DELEGATED ADVERTISEMENT DECISION

70028/ADV/2014/36 201 - 203 HIGH STREET

Installation of 1 externally illuminated fascia sign and 1 externally illuminated hanging sign.

Client Wagamama Address/Job details 201-203 High St Uxbridge UB8 1LB	
Proposed Signage			
Job No			
Drawn by DN	Date 27/04/23	Drawing No 596750-2	Rev A
Scale As specified (A3)

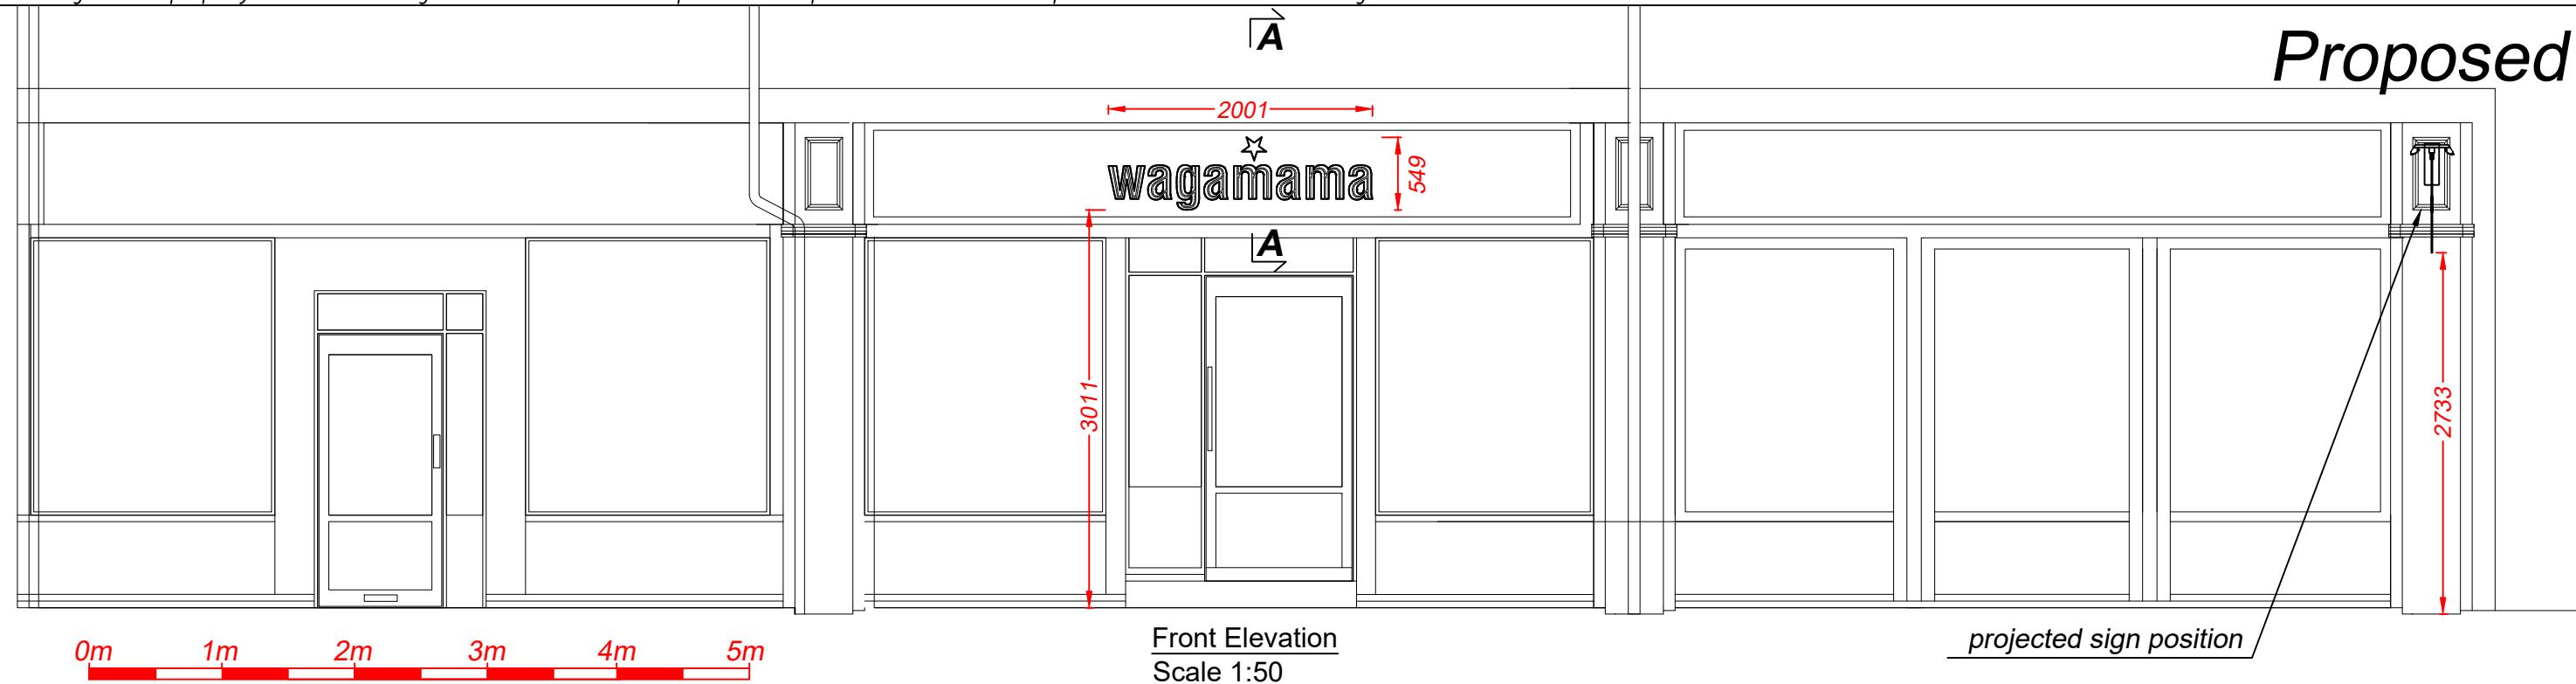
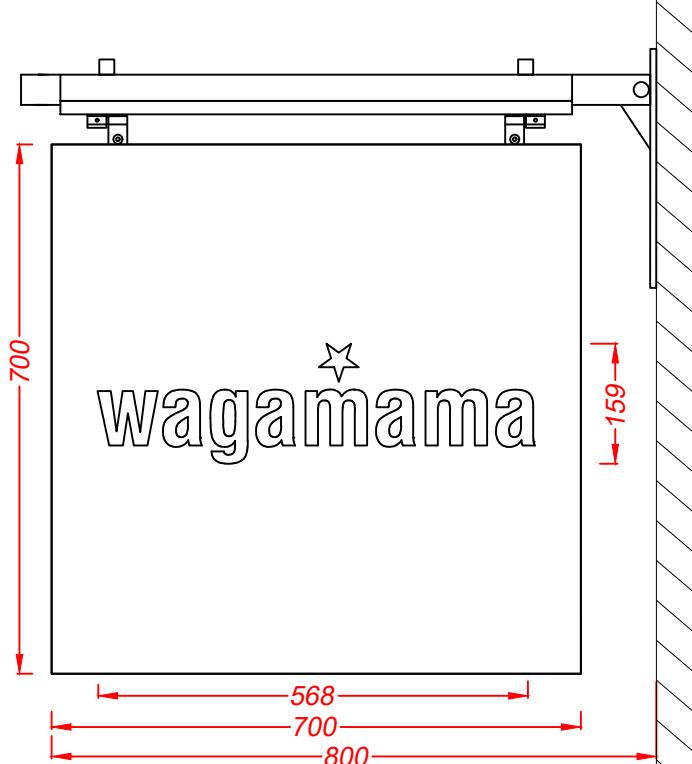
During the course of the application, amendments were sought to amend the fascia sign to be halo lit rather than internally illuminated and to amend the projecting sign to be externally illuminated in the form of a trough light, rather than being internally illuminated.

As the site lies within Old Uxbridge / Windsor Street Conservation Area, internally illuminated signs are not normally permitted as they are considered to cause harm to the character and appearance of the conservation area. On this occasion, due to the variety of illumination styles present along the high street, a 'halo lit' fascia sign is considered an acceptable alternative.

The existing fascia sign is similar in visual appearance to the pre-existing fascia sign. The difference being the replacement of the external illumination in the form of a trough light with halo lit letters, lit with low energy LEDs. The proposal also includes retrospective permission for a projecting sign, which will be lit externally in the form of a trough light.
